CITY OF ALBUQUERQUE

Re: Avengers Daycare
9901 Central Ave NE NM 87123
30-Day Temporary Certificate of Occupancy- Traffic Certification Only
Transportation Development Final Inspection
Engineer's/Architect's Stamp dated 06-21-2018 (K20D064)
Certification dated 03-04-2019

SITE PLAN / TRAFFIC CIRCULATION LAYOUT

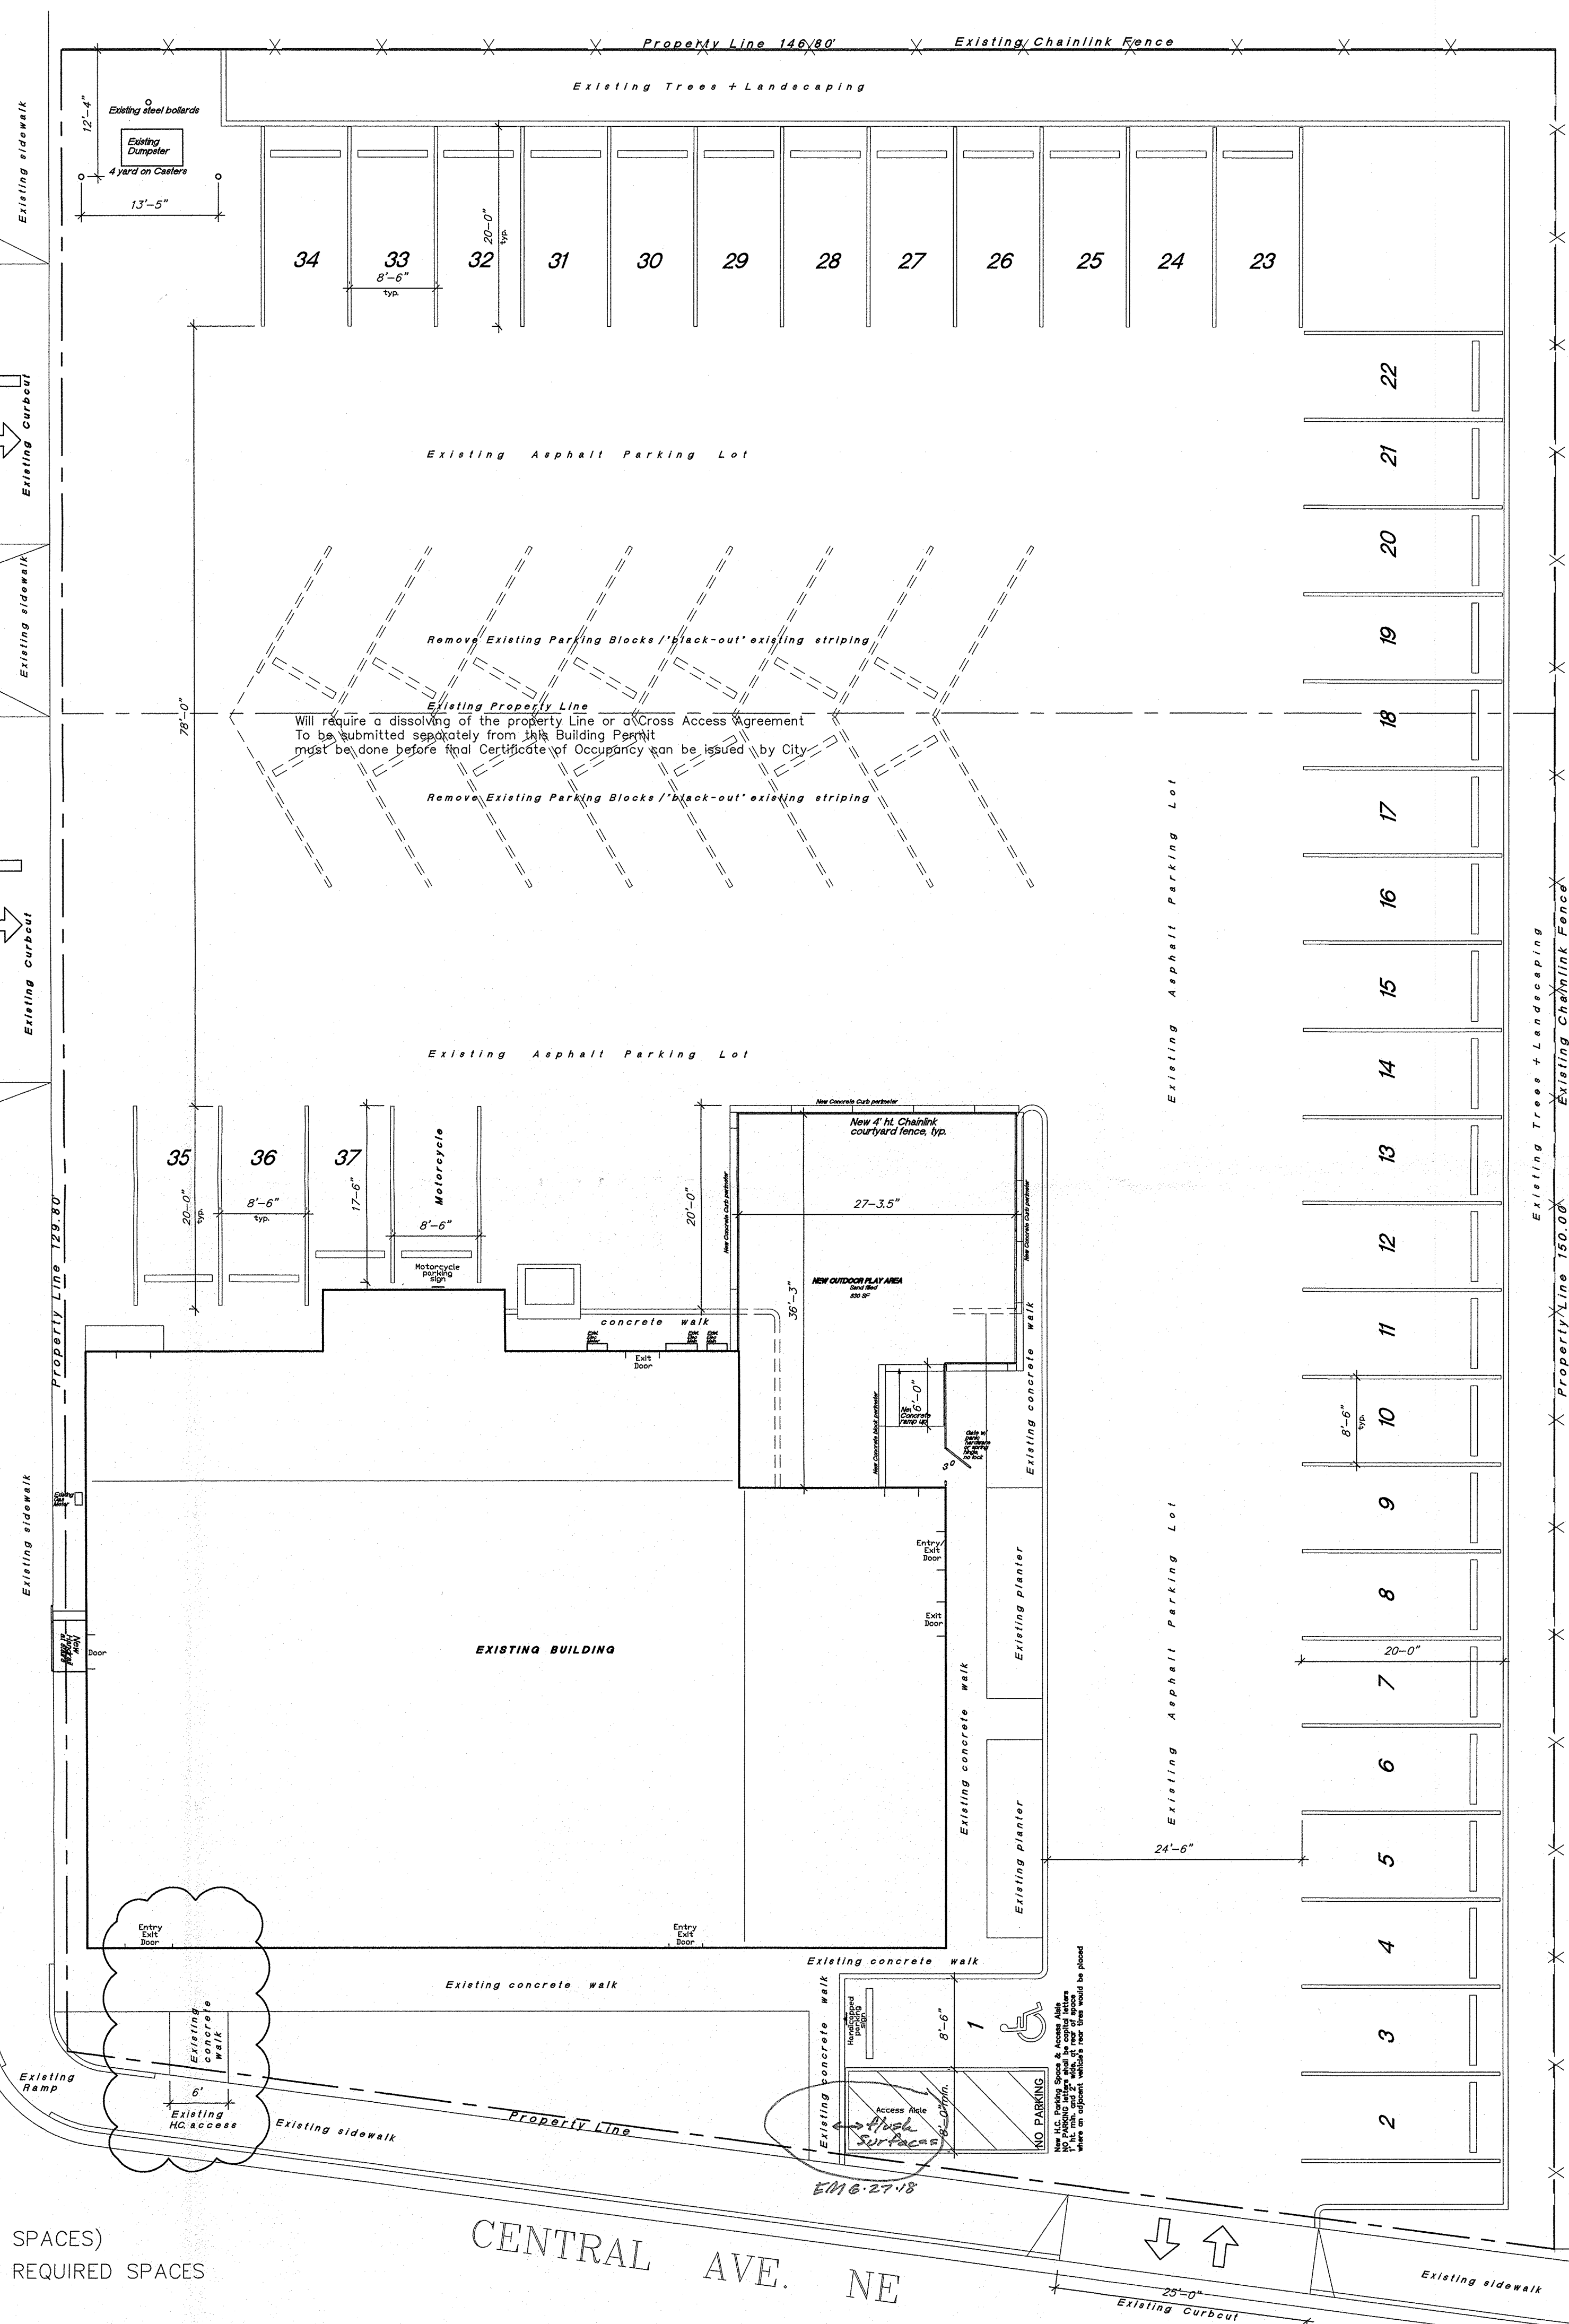
1. Please remove the temporary fencing.
2. Please remove all debris from the parking area.
3. You may send a photo of the correction to mmaadandar@cabq.gov for release of final CO.
